PROPOSED: Conversion of barn to dwelling, change of use of agricultural land to create garden area, new vehicle access and siting of new sewage treatment plant. Hill Foot Barn, Twiston (3/2011/0826)

Doug Moir
Planning Officer (Archaeology)

Title Proposed Alterations
Plans, Elevations and Section

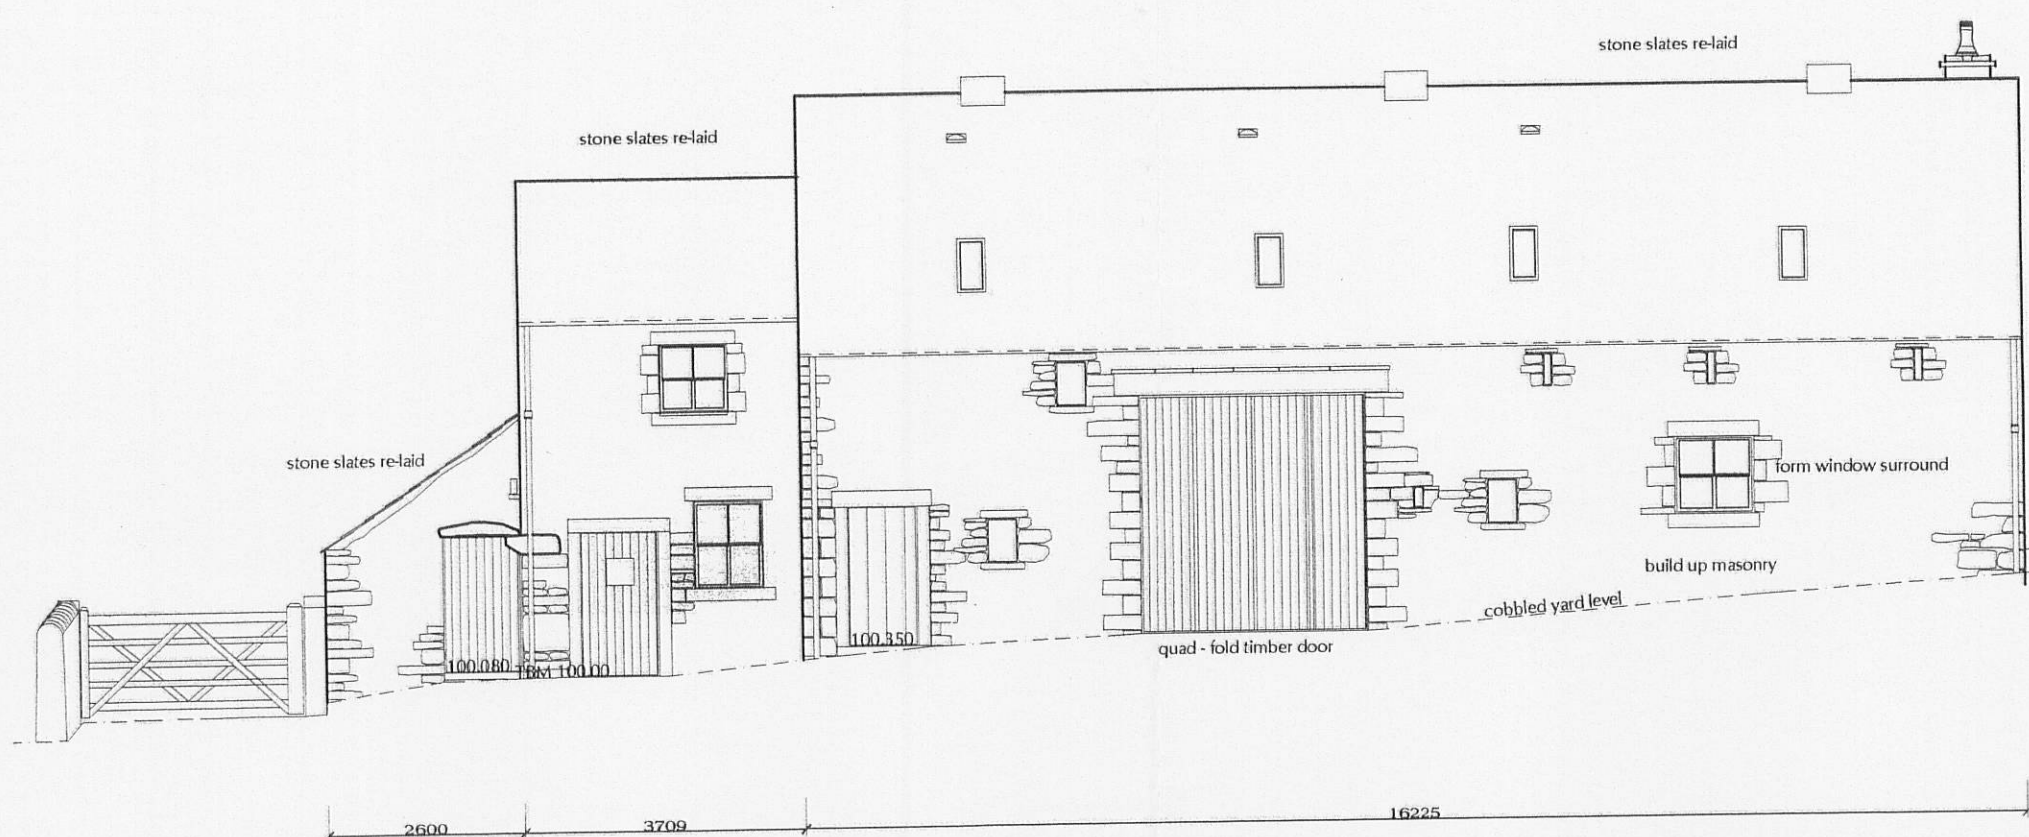
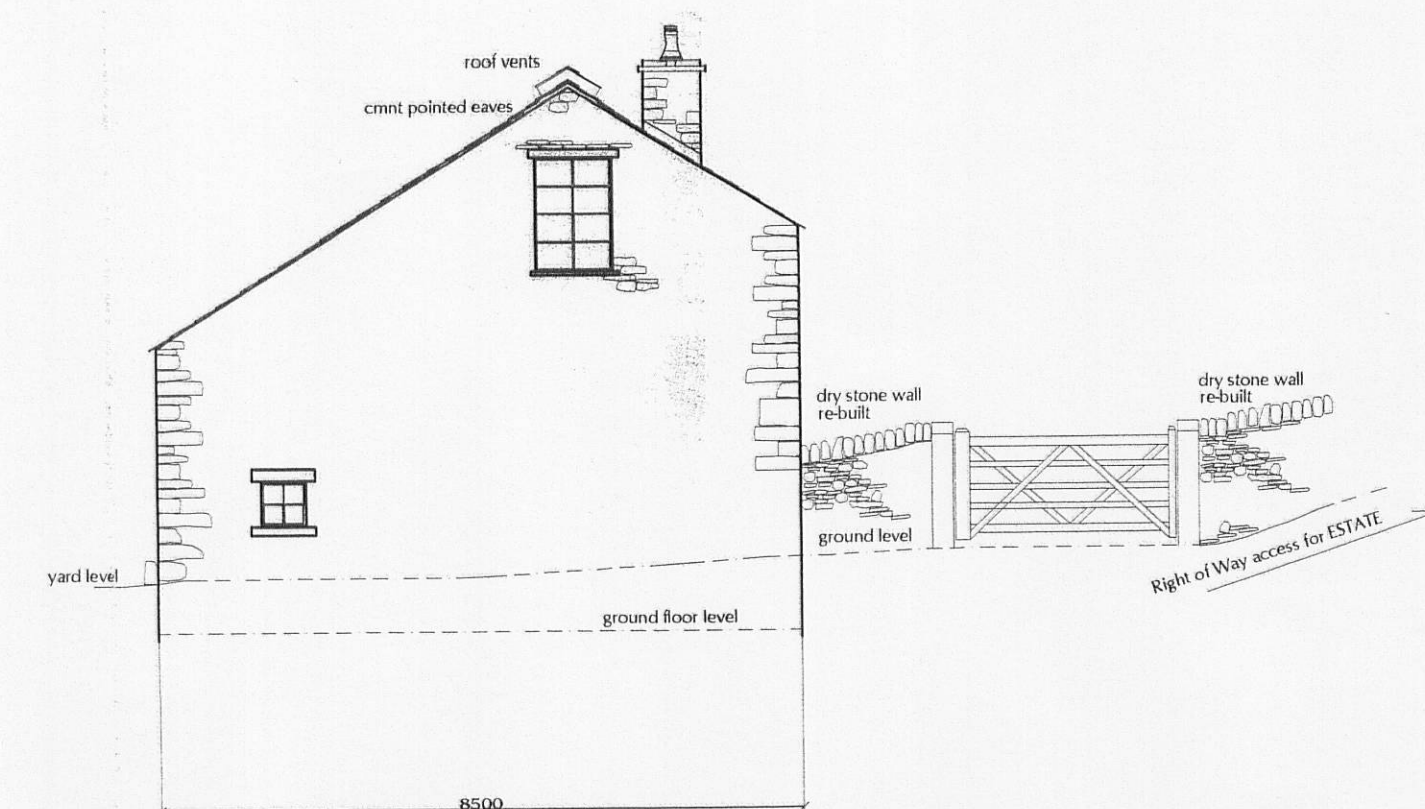
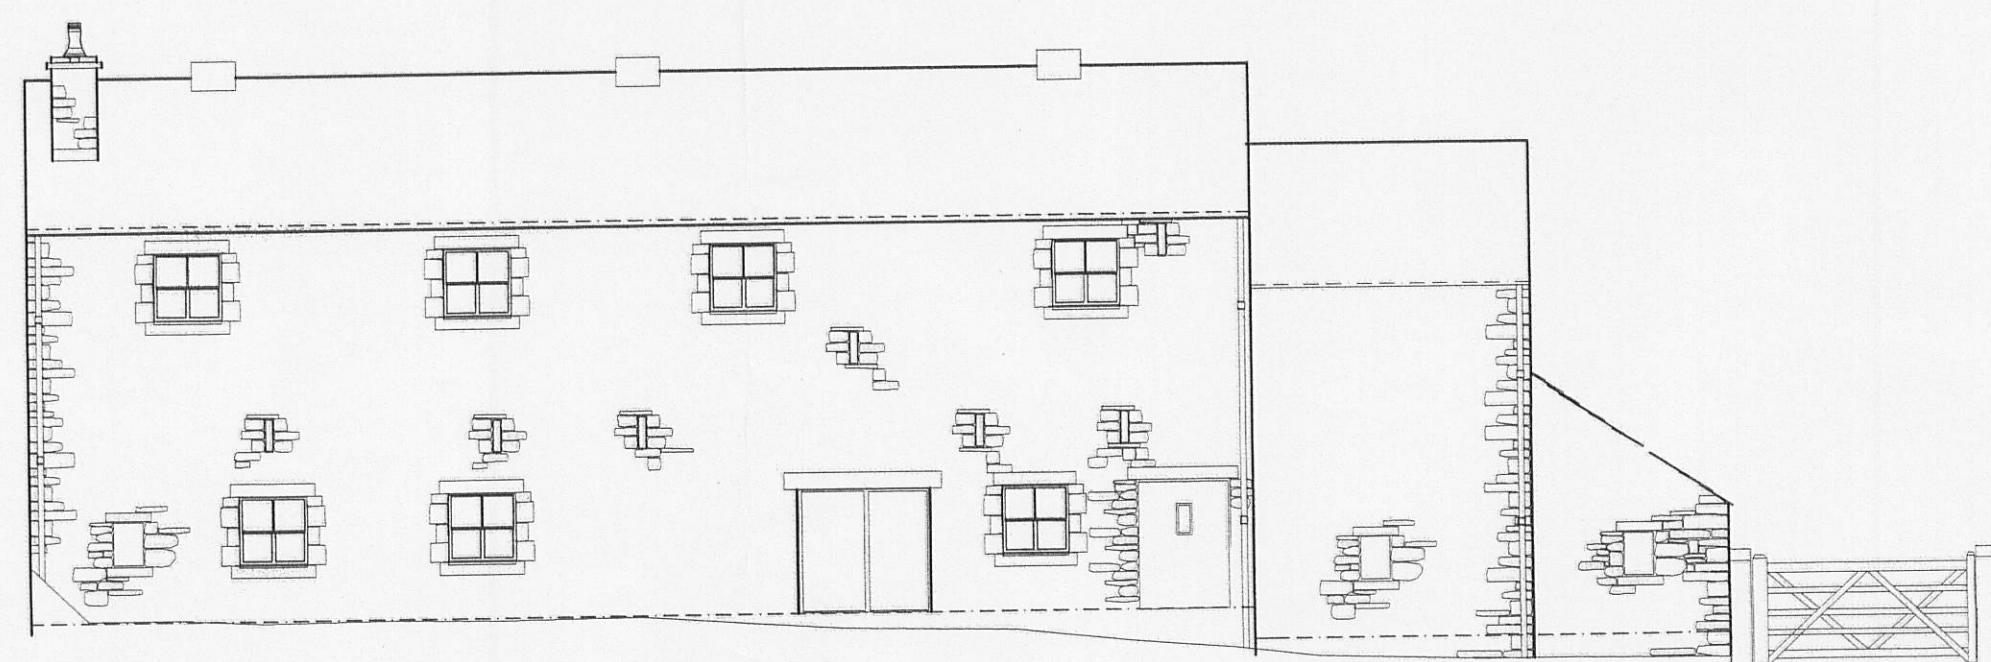
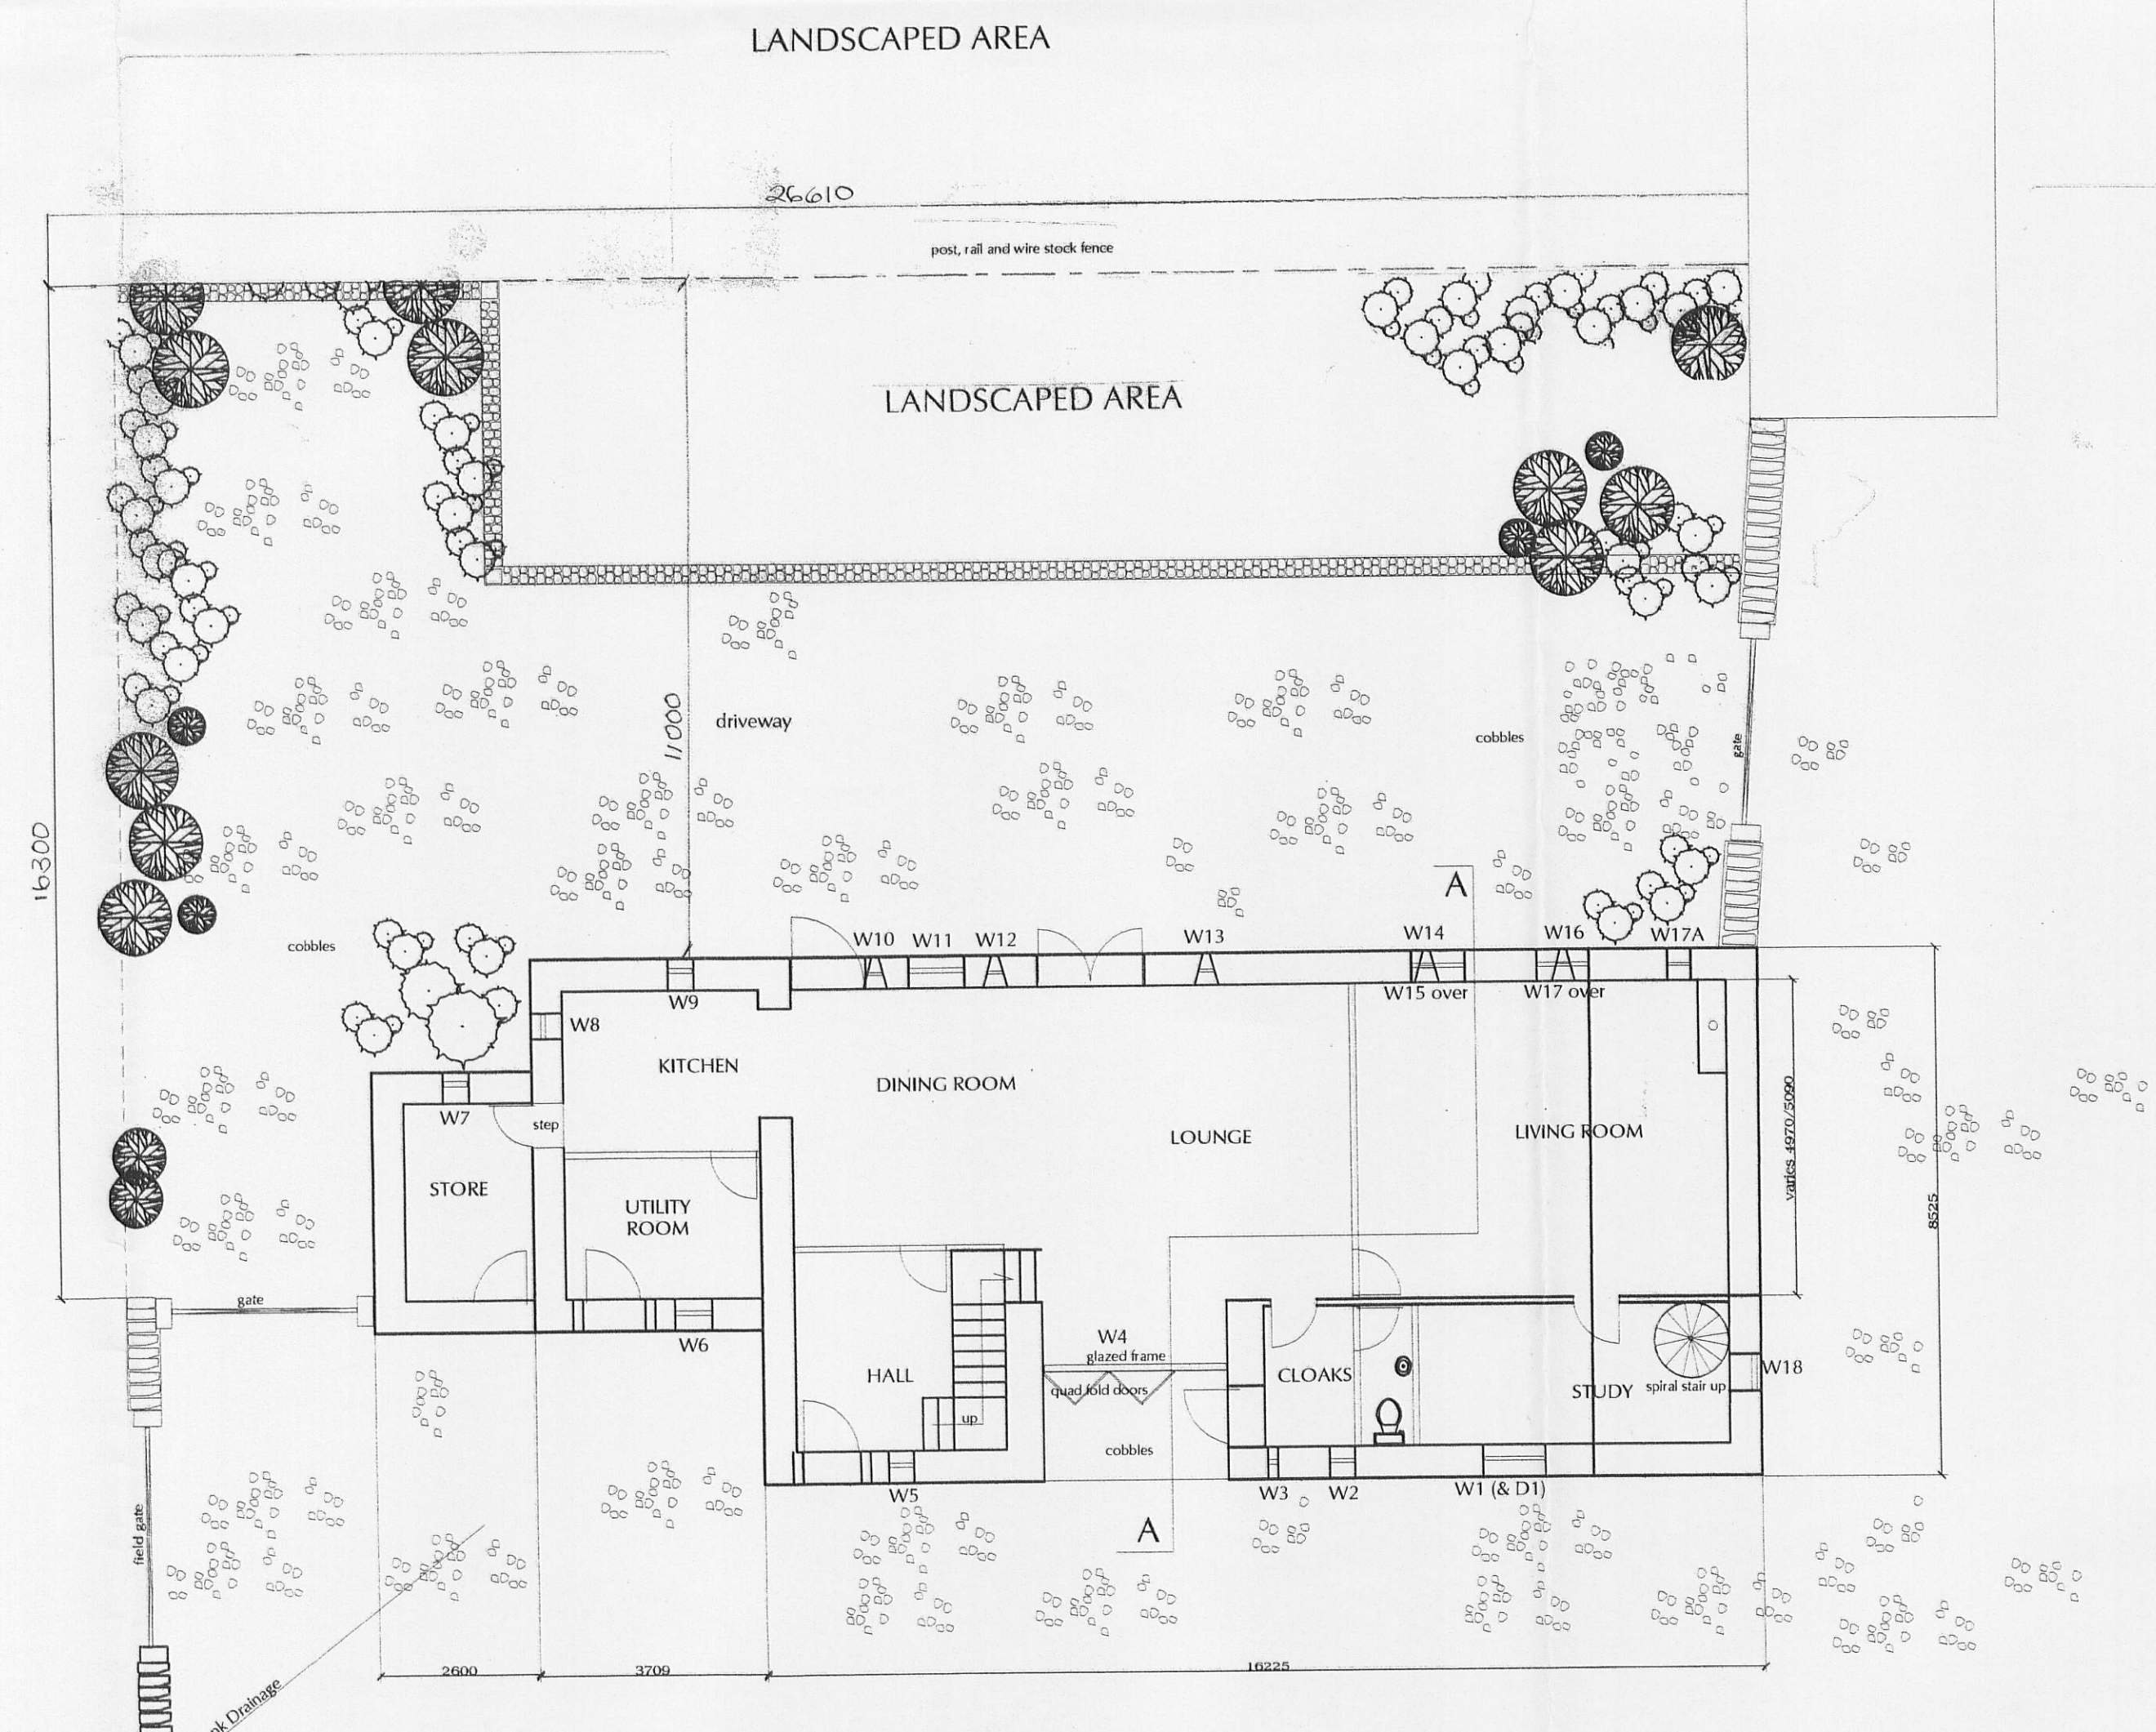
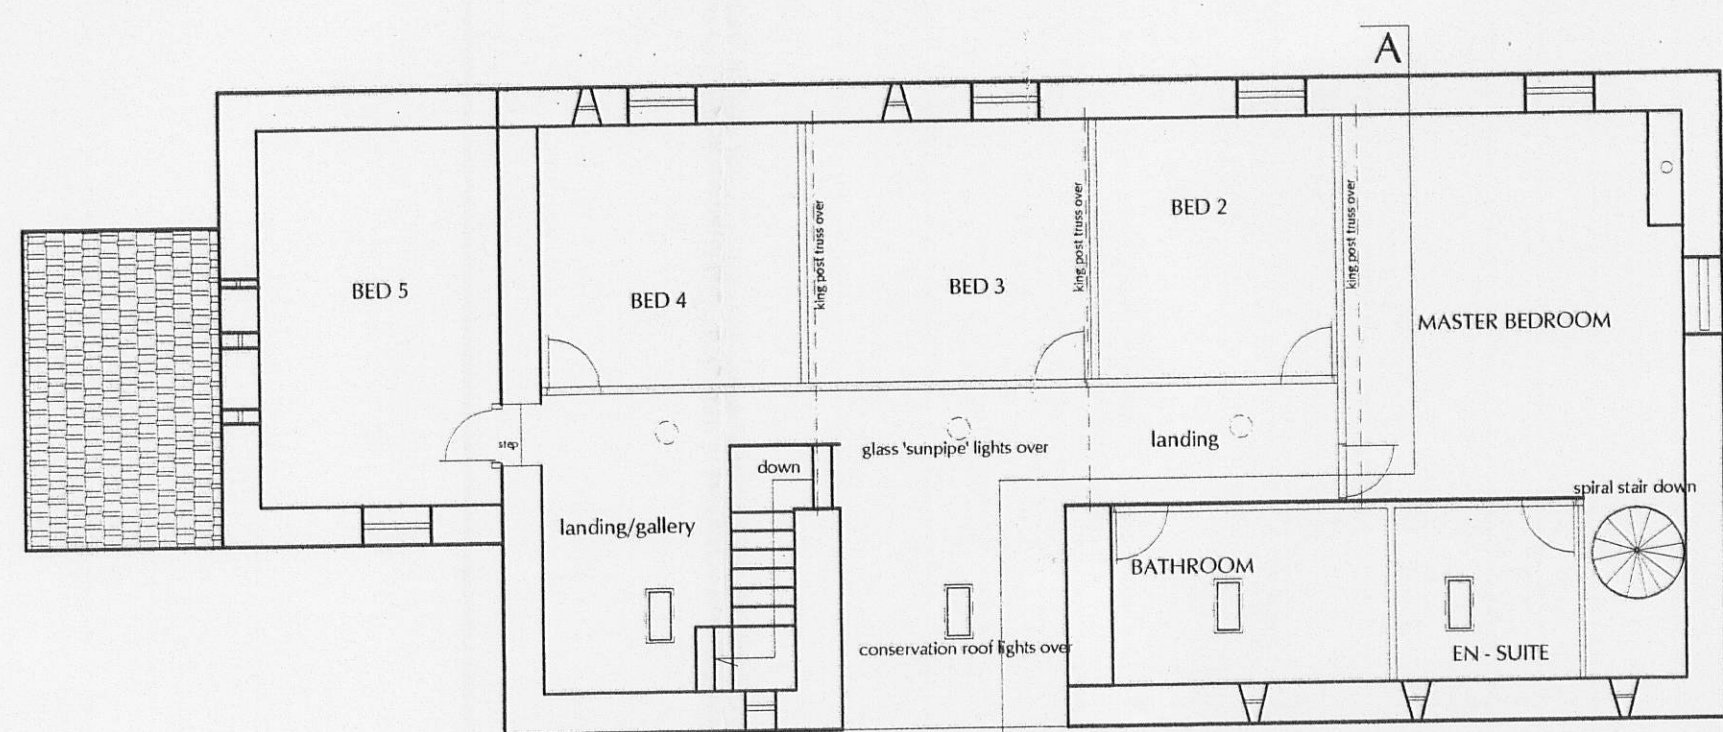
Barns are often characterised by long unbroken expanses of roof and walling, and LCAS would therefore recommend that consideration be given to requiring the applicants to reduce the number of proposed new openings. Similarly such buildings are often recognisable by the use of wooden shutters and large boarded doors to the cart entry. LCAS would also recommend that consideration be given to requiring the applicant to retain such features where possible. In this instance there appears to be no real need to replace the existing cart entry door with the proposed folding doors.
